WATERLOO METRO QUARTER BUILDING 3&4

SSD-10437 - RESPONSE TO SUBMISSIONS
SUPPLEMENTARY DESIGN REPORT

PREPARED FOR WATERLOO DEVELOPER PTY LTD
DOCUMENT NO. WMQ-BLD34-BSA-AR-RPT-DA210

Date of Issue 12.02.2021

**Figure 18 – Detailed Design Terrace Areas Wind Comfort Results – Winter Period**

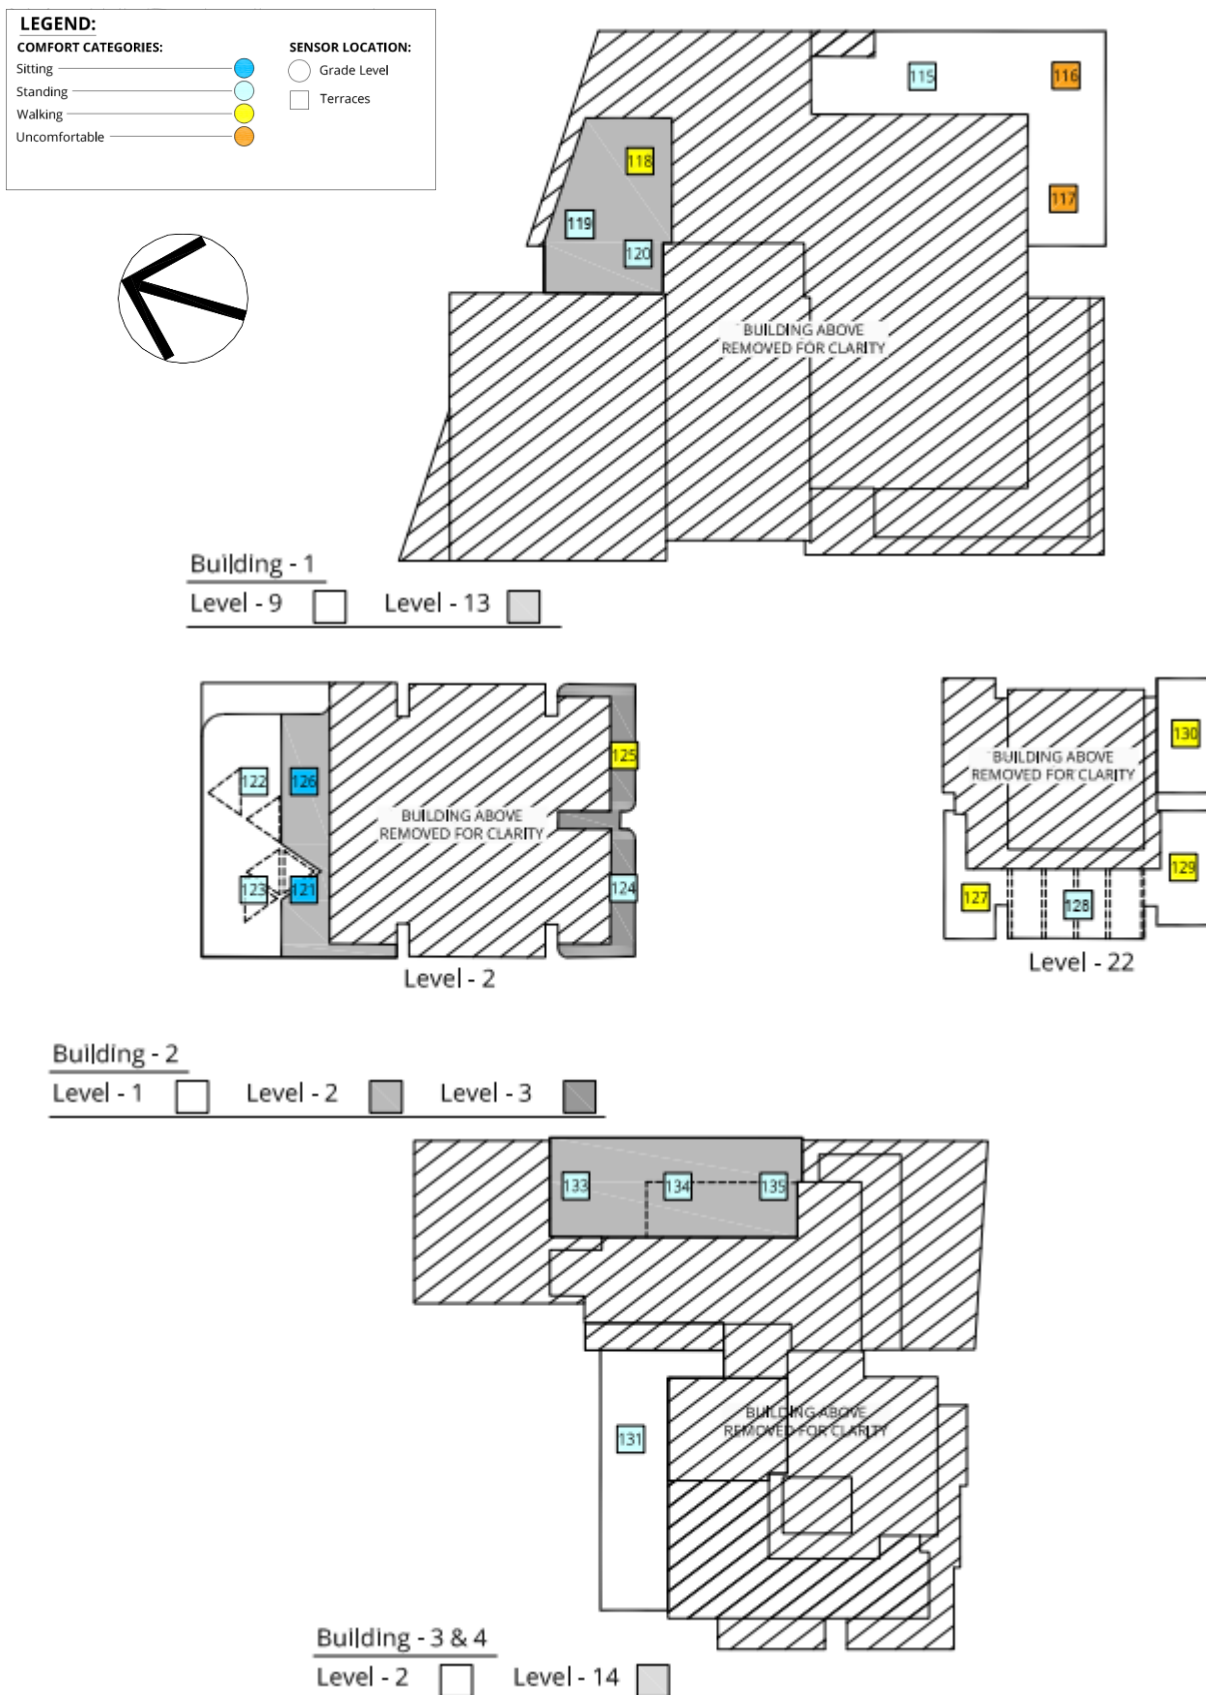
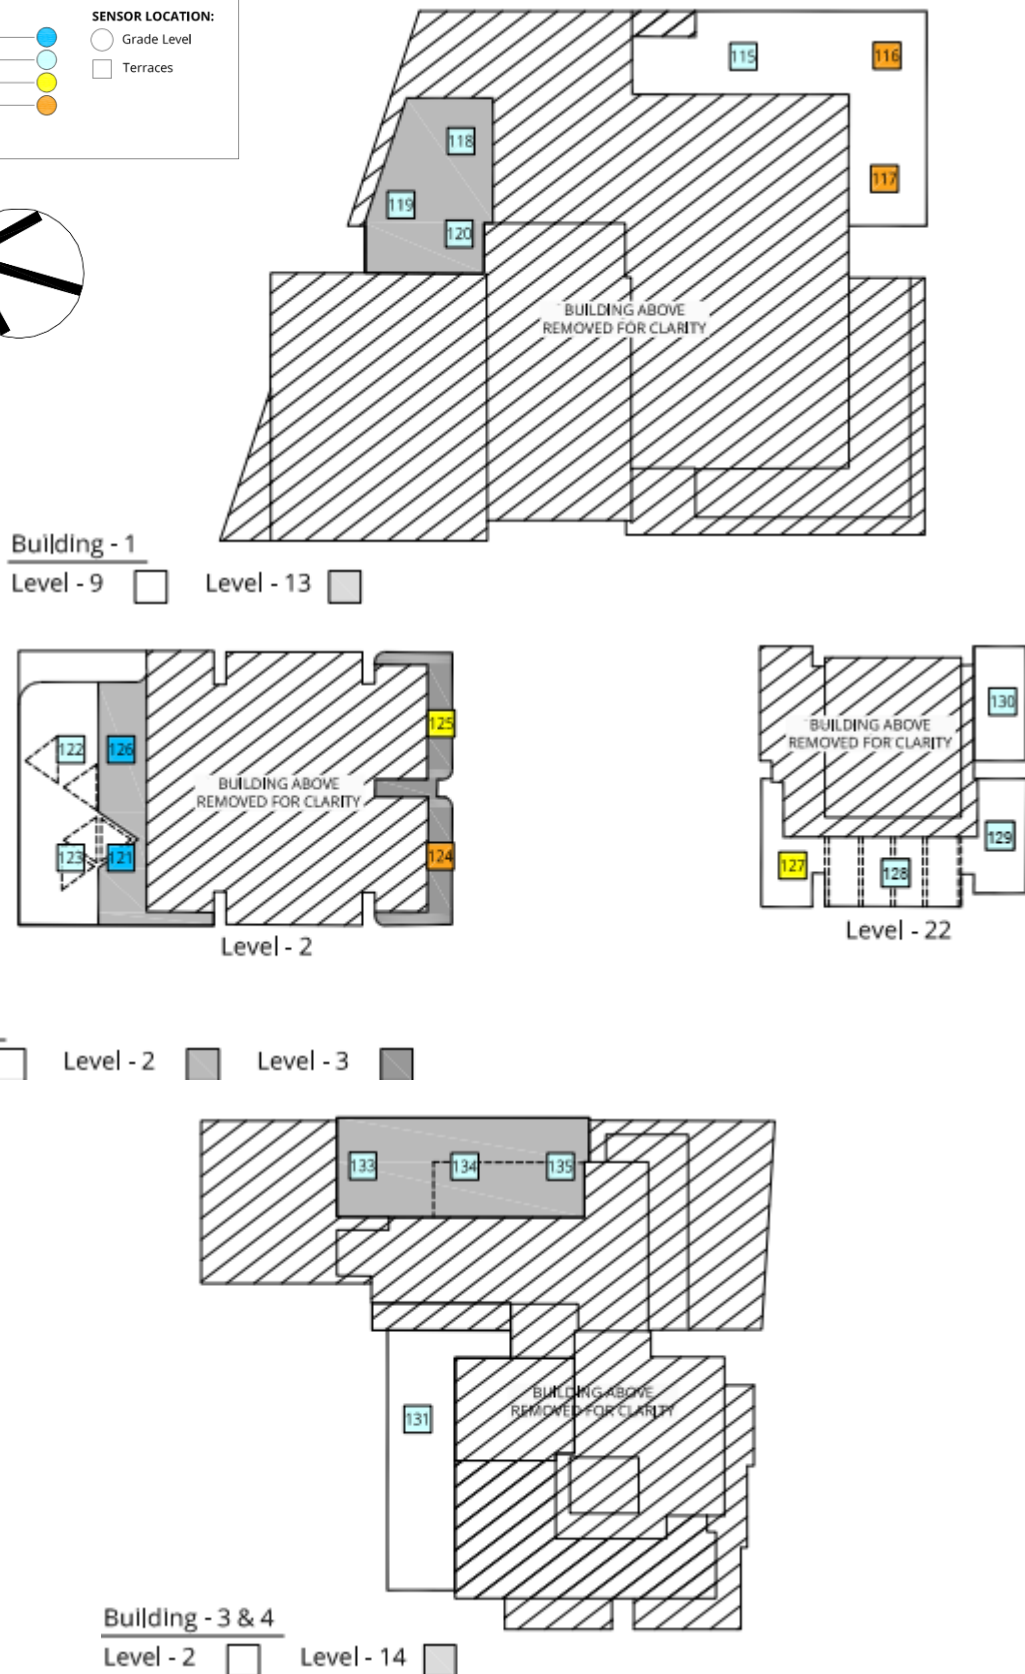
The wind report identifies that the communal terrace will only achieve the standing comfort criteria, even accounting for mitigation measures. It is preferable that further design work be undertaken to try to improve the amenity of this area for residents such that it meets the sitting comfort criteria.

The wind conditions affecting the Building 3 roof terrace are primarily generated from downwash from the tower above.

The pergola to the communal roof terrace has been developed in response to the City of Sydney comments by amending the following:

- / Pergola moved further west to align with the tower above
- / Pergola length increased
- / The pergola is proposed to have operable openings to allow for solar access in winter whilst still providing weather protection

Pergola moved further west (towards Botany Road) and length increased to help reduce wind downwashing off the tower form above to improve wind conditions on the communal terrace
